**Proposed Increased Throughput at an Existing Resource  
Recovery Facility- Wood/Plasterboard Recycling  
25 Dunheved Circuit, St Marys**

**SSD 10474**

**Response to Submissions Report**

PROJECT	25 DUNHEVED CIRCUIT, ST MARYS		
TITLE	SWEPT PATH ANALYSIS - SUBJECT SITE AS2890.2 12.5m HEAVY RIGID VEHICLE

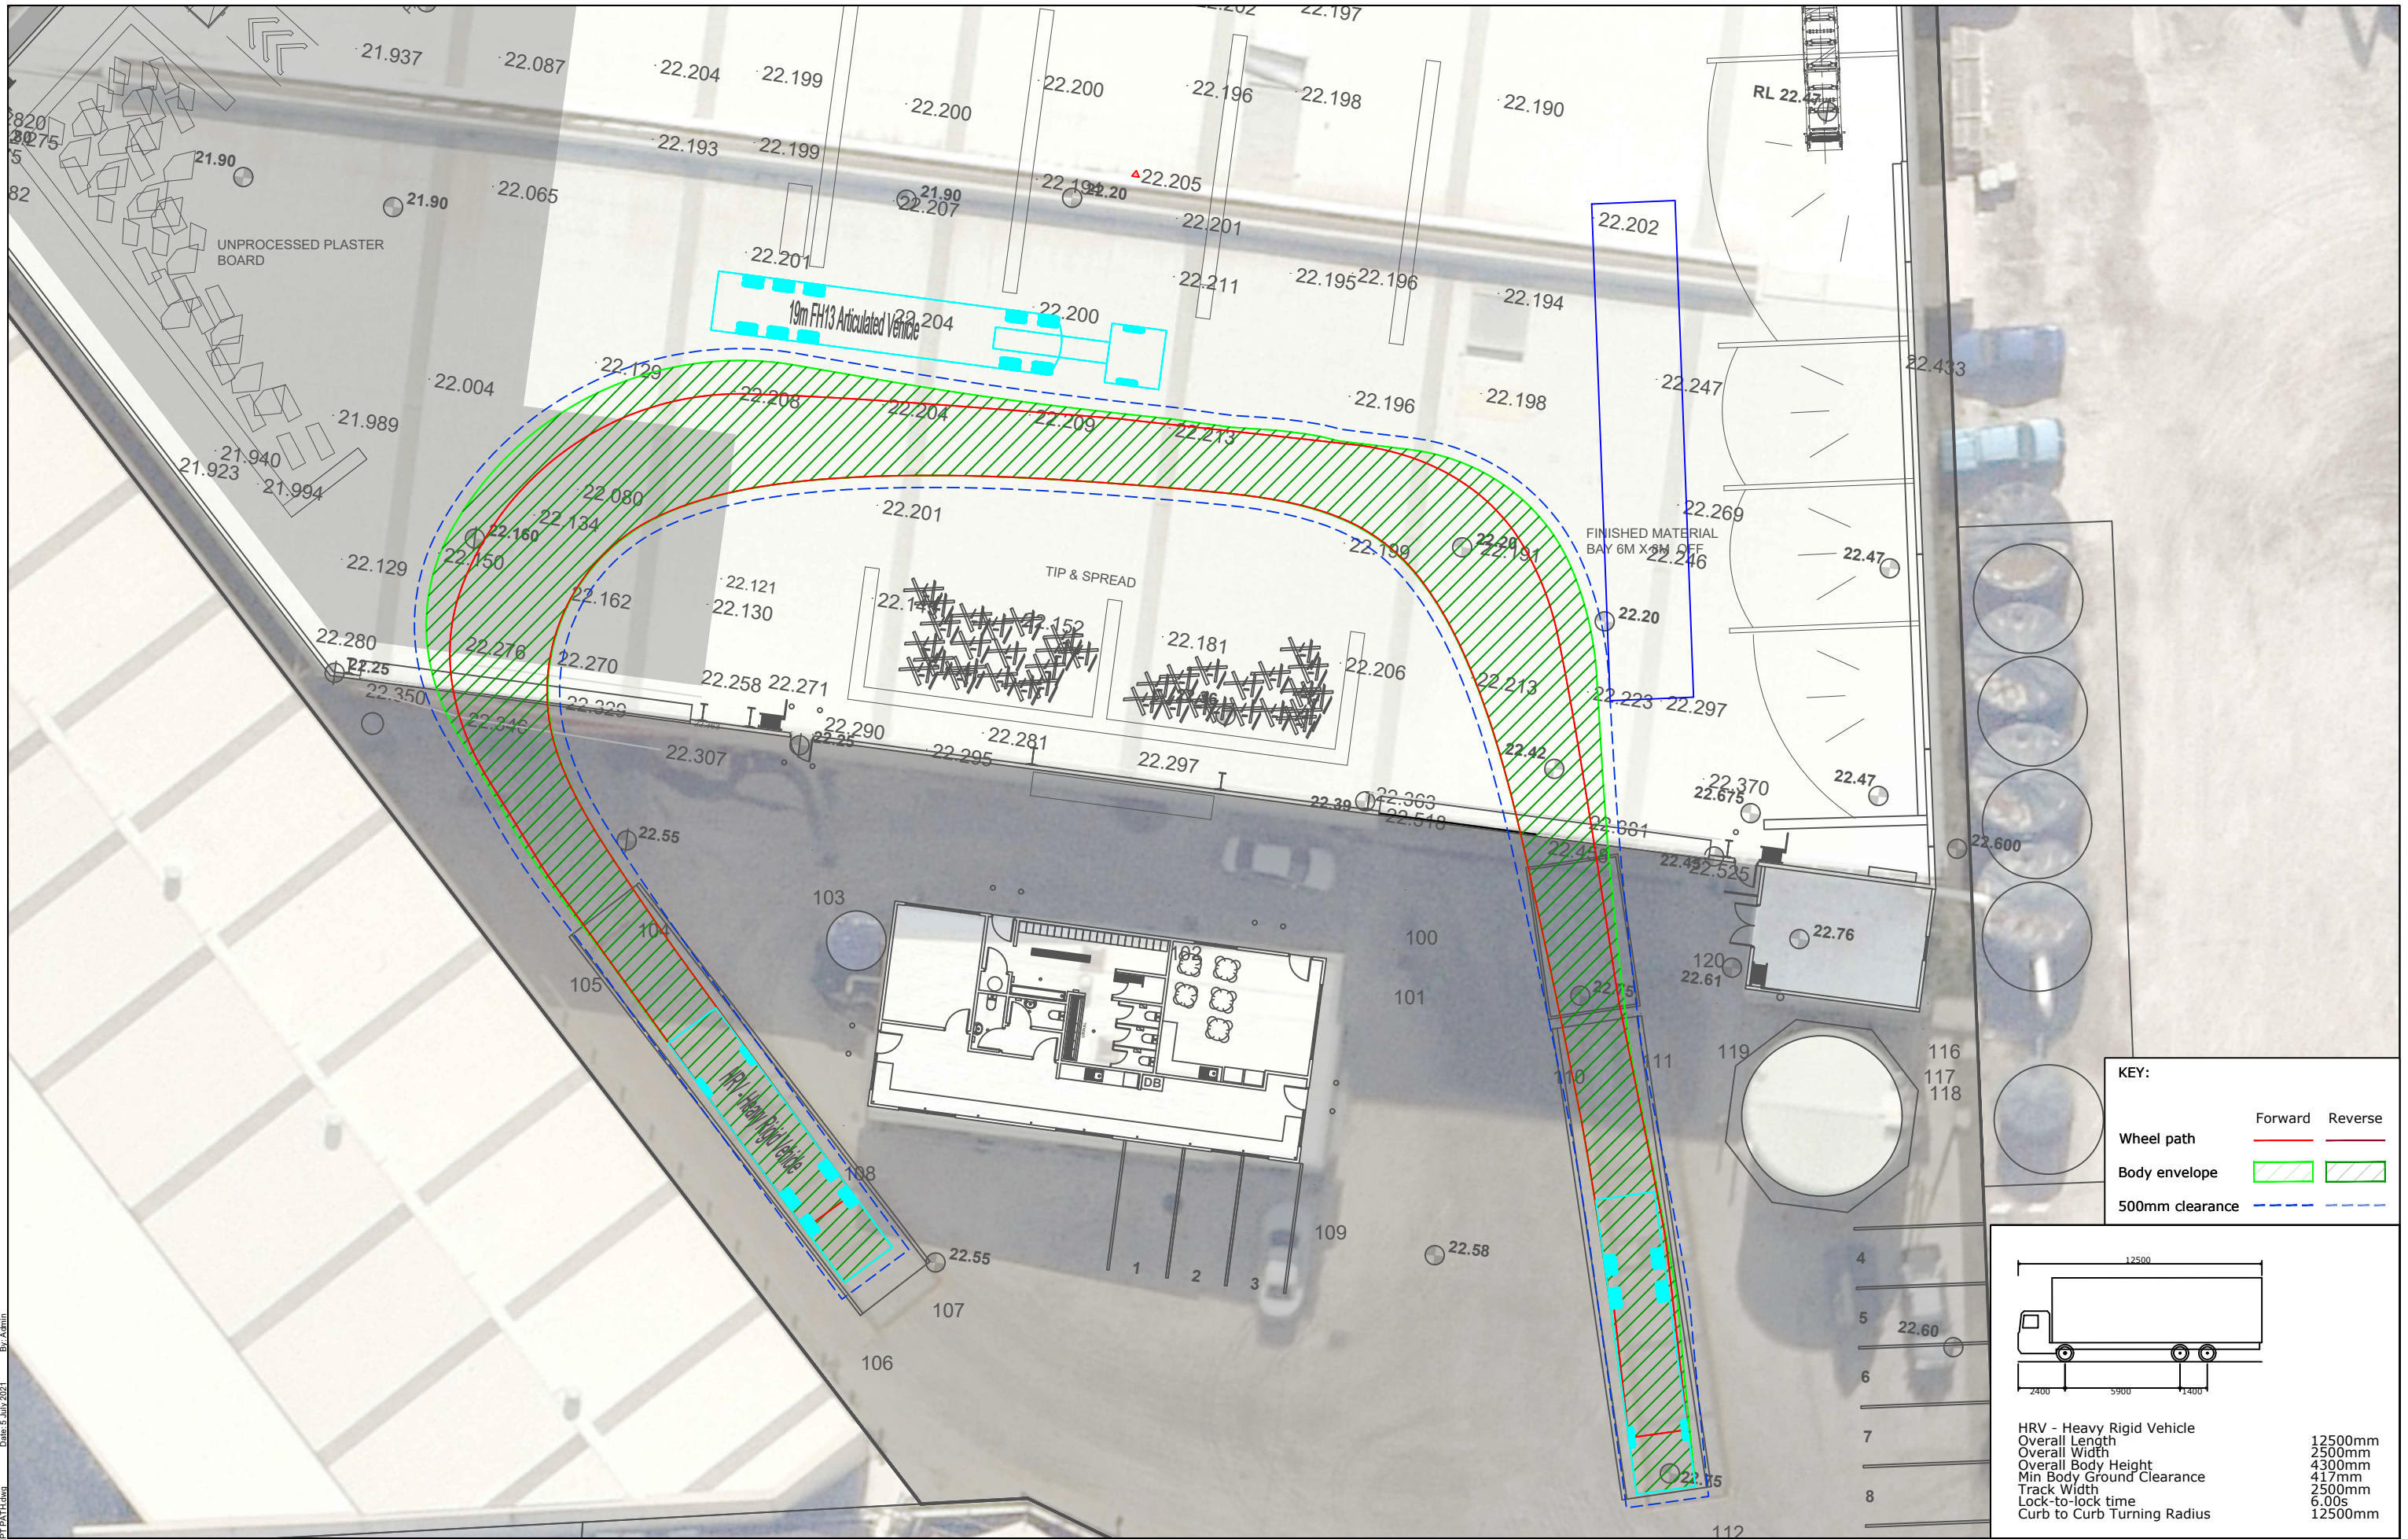
DPIE requested more details of on-site traffic management and parking arrangements. DPIE also requested more information about the site access driveway. The proponent was also required to seek information from Penrith Council on the timing of the construction of the proposed extension of Links Road to Christie Street.

DRAWING
PROPOSED GROUND FLOOR PLAN

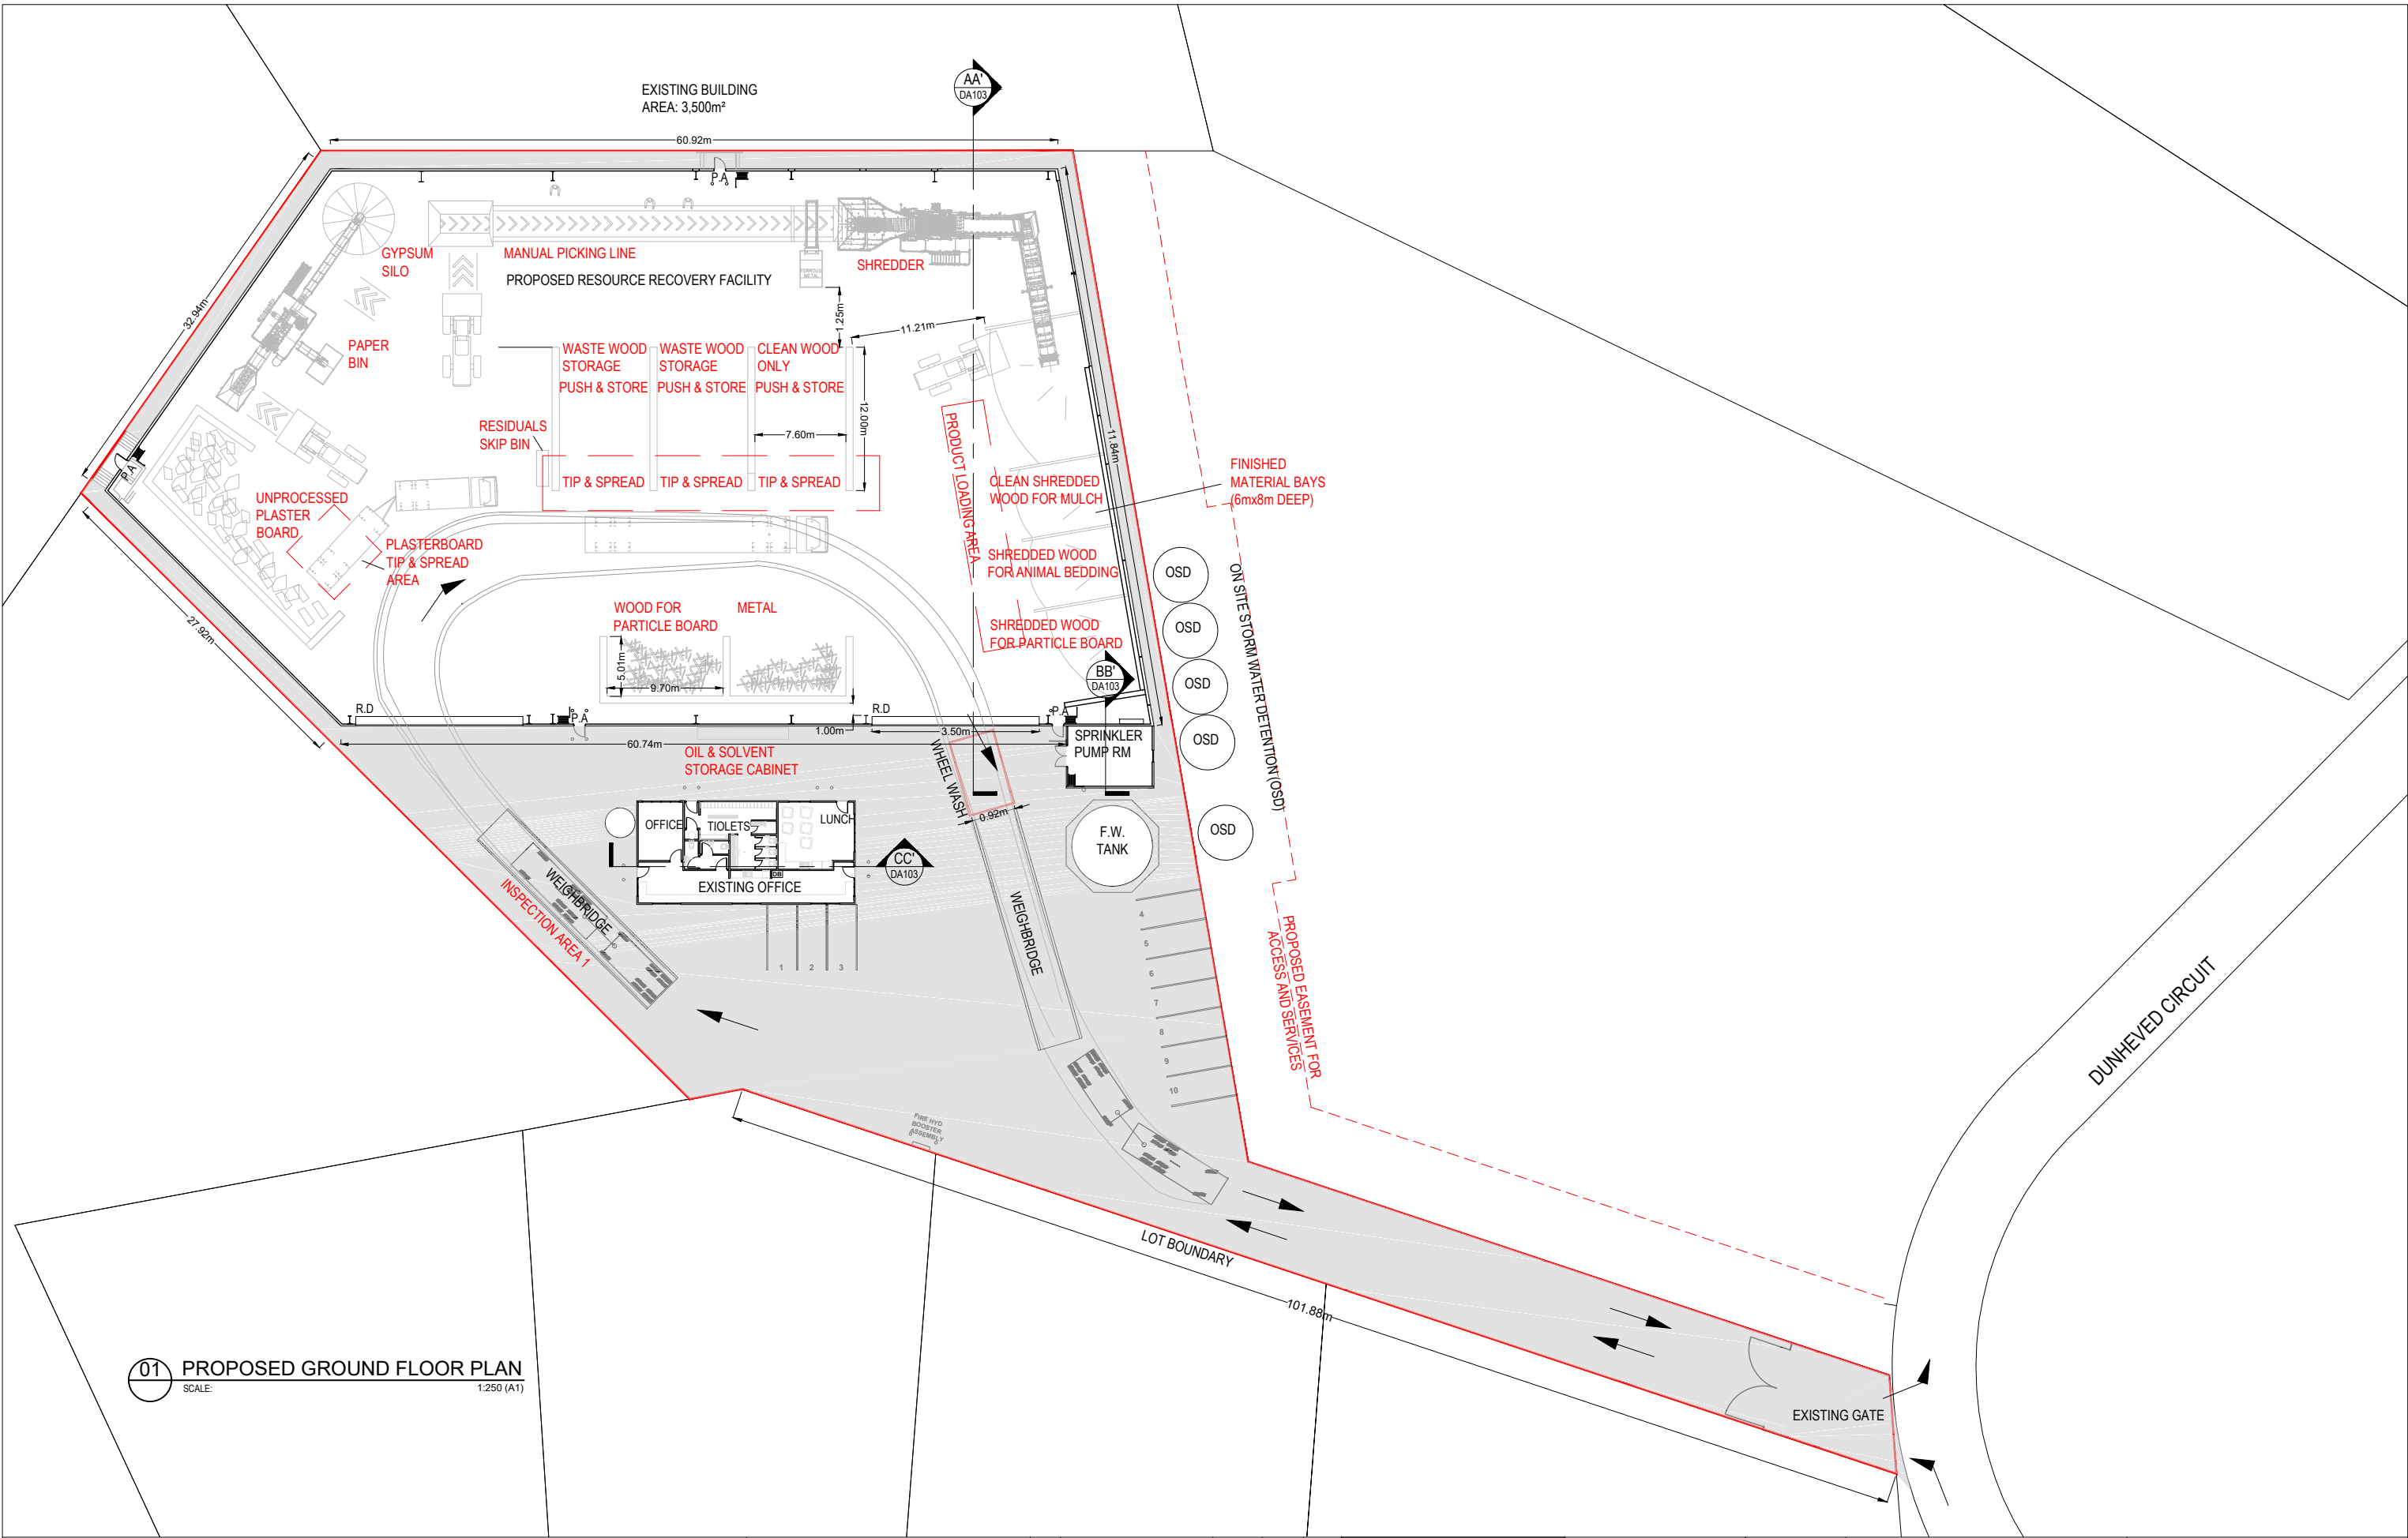
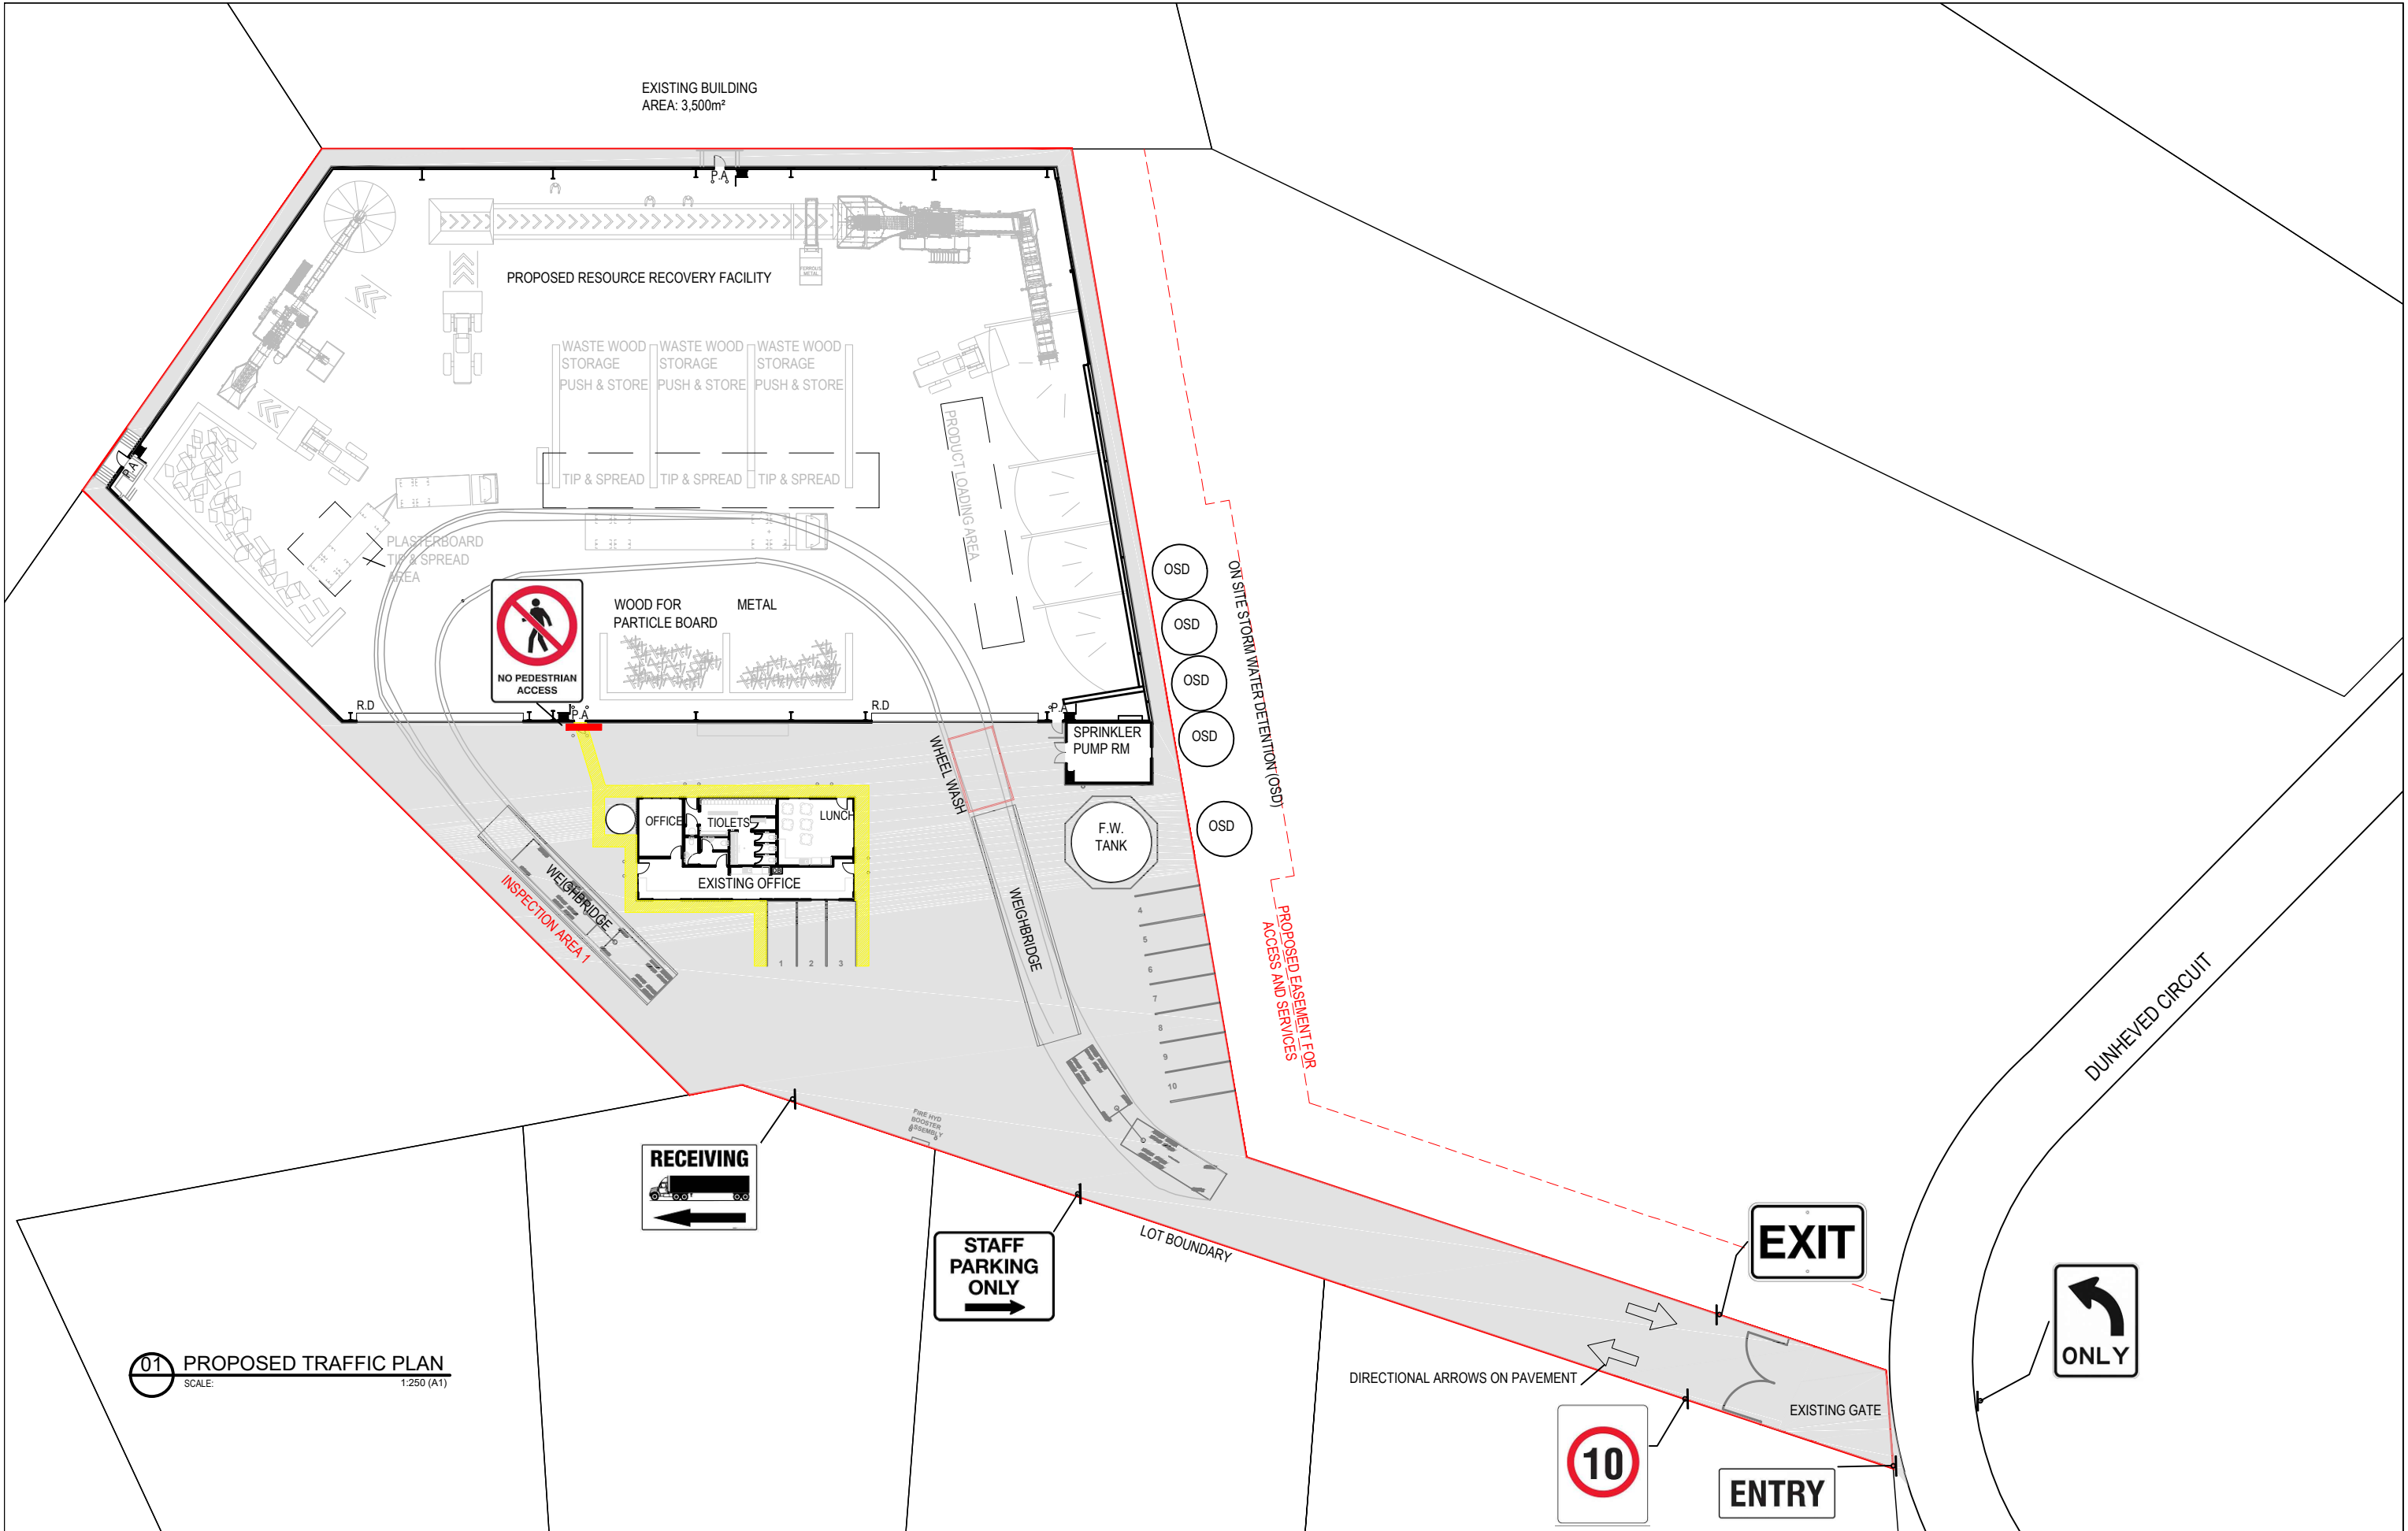
The site plans have been updated to address the inconsistencies noted in the comments and to clarify the operational areas. The main change to the site design has been to allocate a dedicated storage bunker to scrap metal storage, instead of proposing to store metals in a skip bin. A copy of the updated site plans is provided at Appendix C.
